Northampton Gateway RFI: Comments on draft documents

These queries relate solely to matters raised by the draft documents, and not the merits of the proposal. They are limited by the time available for consideration, and raised without prejudice to the acceptance or otherwise of the eventual application. They are provided to assist the preparation of the next iteration.

Drawing Title		WORKS PLANS KEY PLAN	
Scale	1:15,000	Drawn	P. Goodyear
Size	A1	Reviewed	S. Hilditch
Regulation	5(2) (j)	Document	2.2
Drawing Status		SUBMISSION	
Drawing No.		Revision	
NGW-BWB-LSI-XX-DR-C-00160		P12

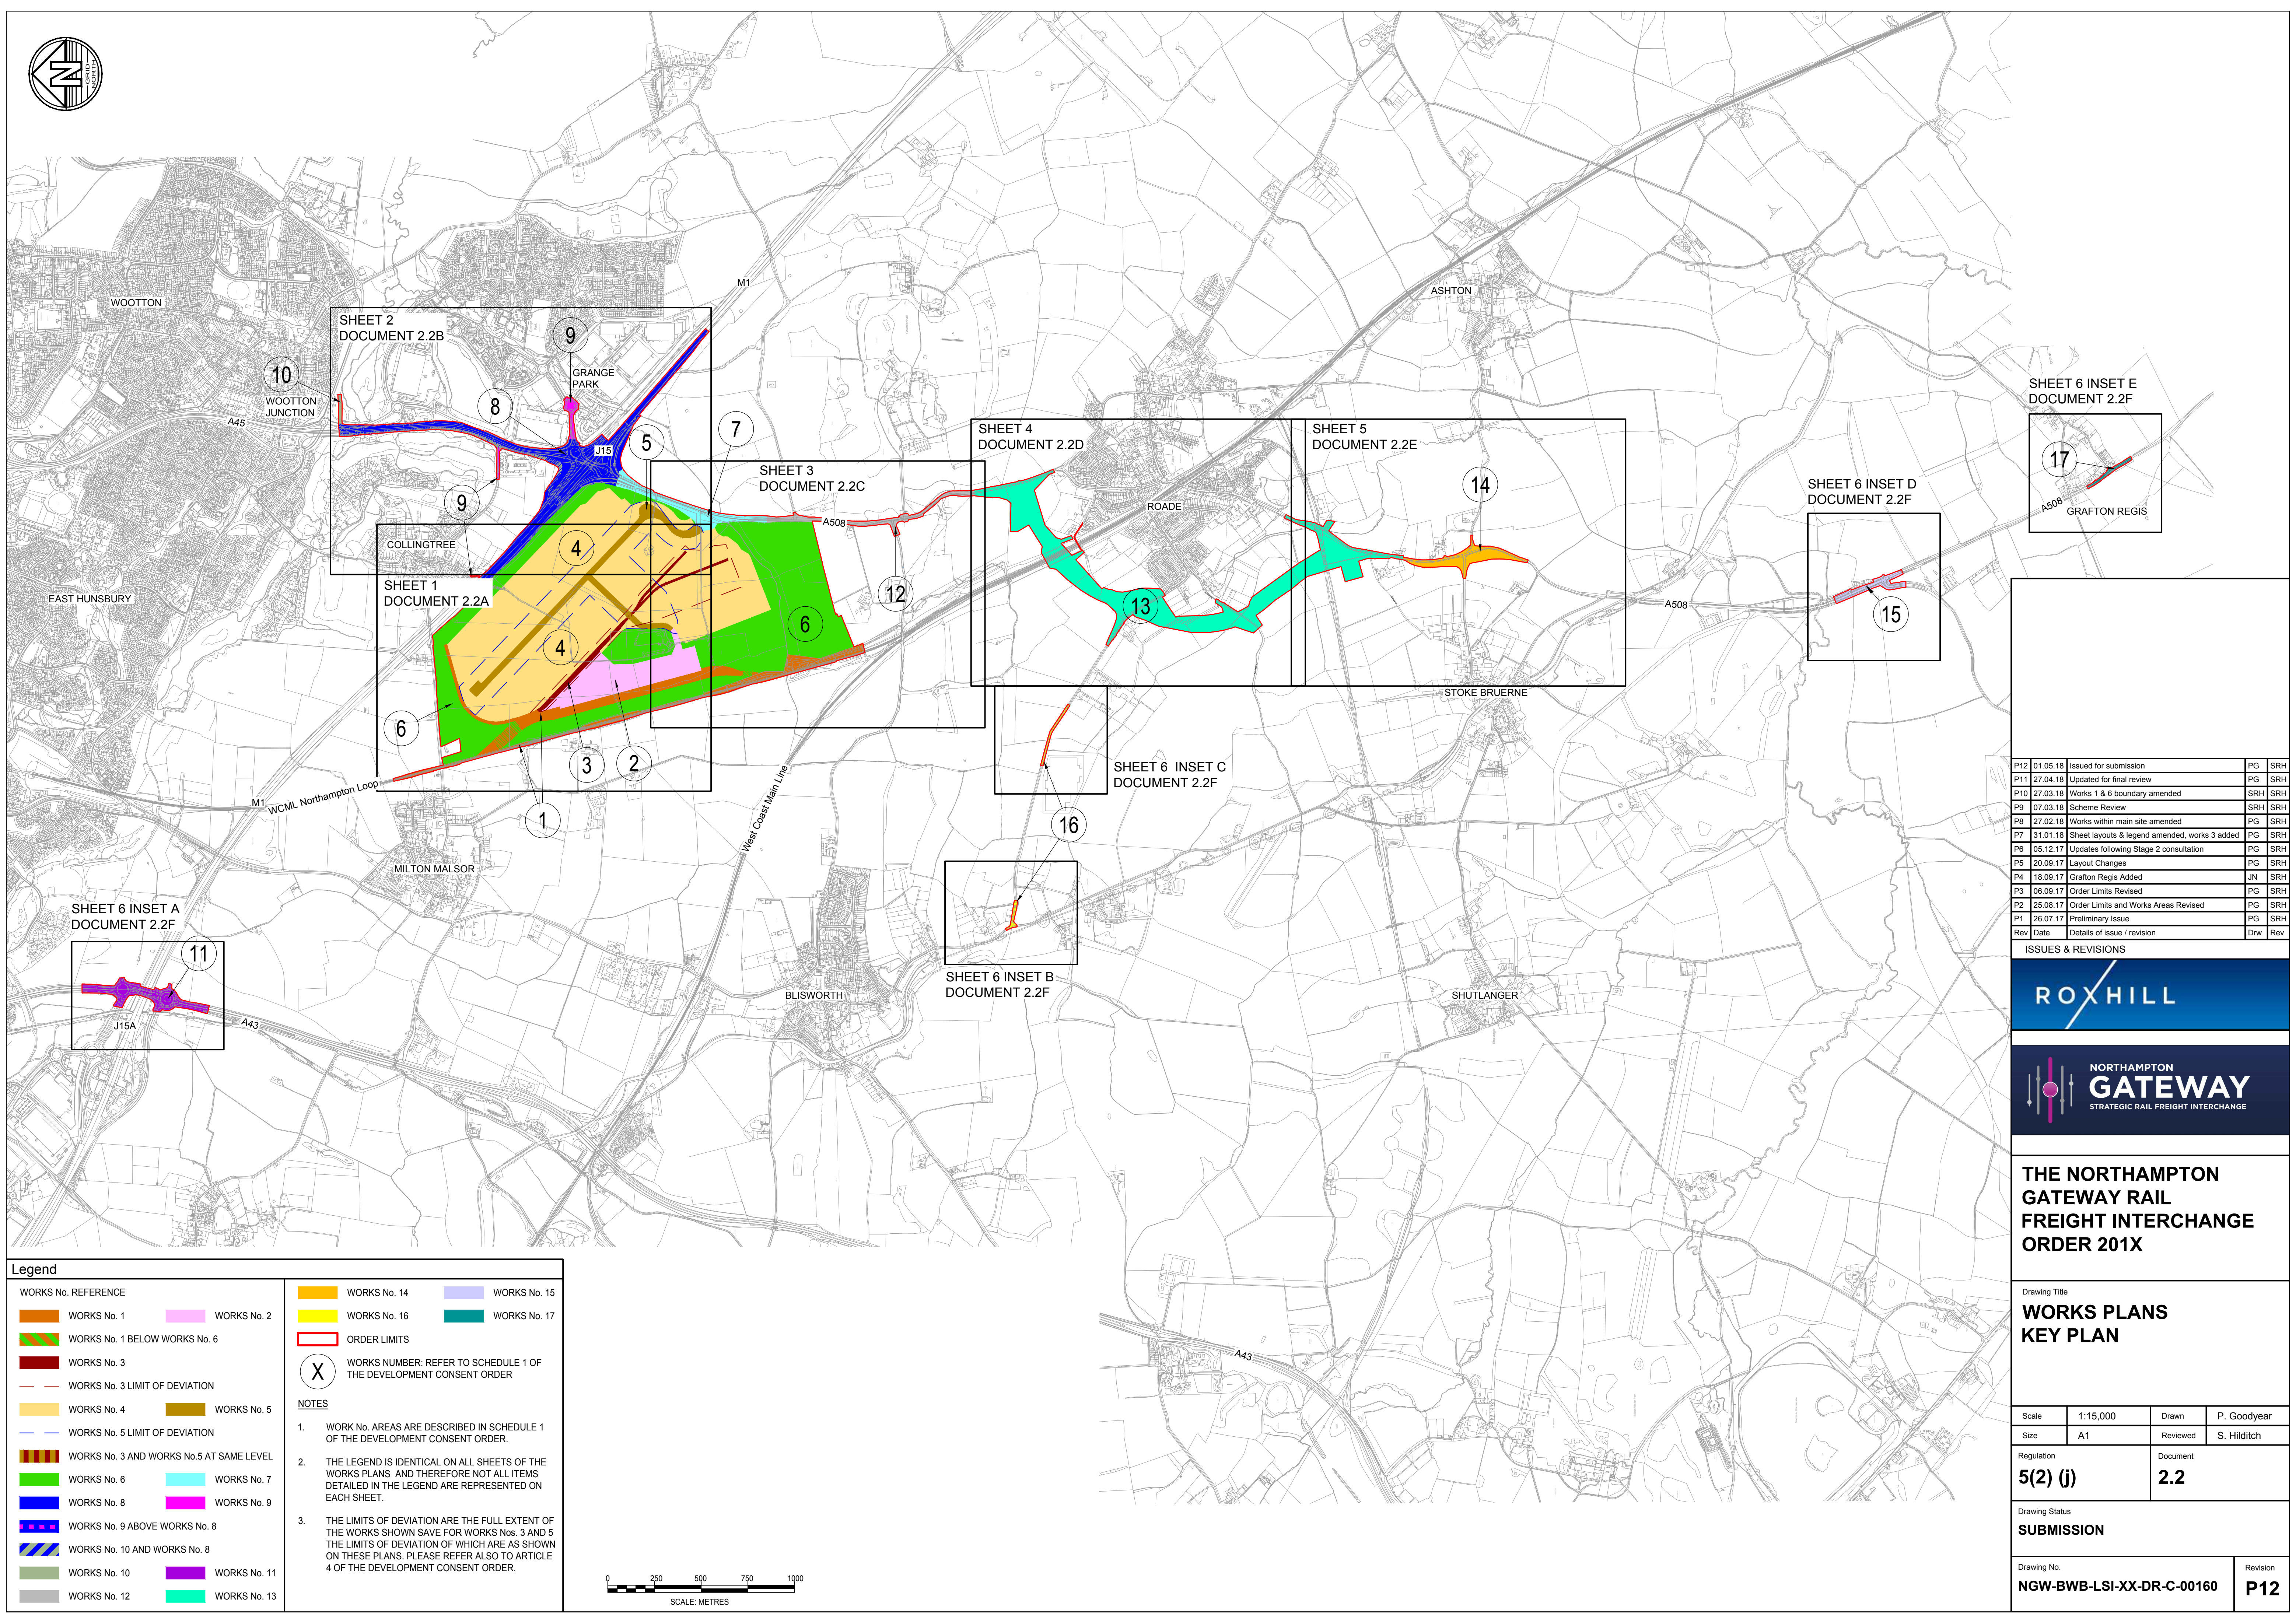
23.	Schedule 1	Works number 2	Some Works as described in the draft DCO do not match the detail on the Illustrative Masterplan or the Works Plans for instance Works no 2 (1)(e) in the DCO contains drainage and attenuation ponds
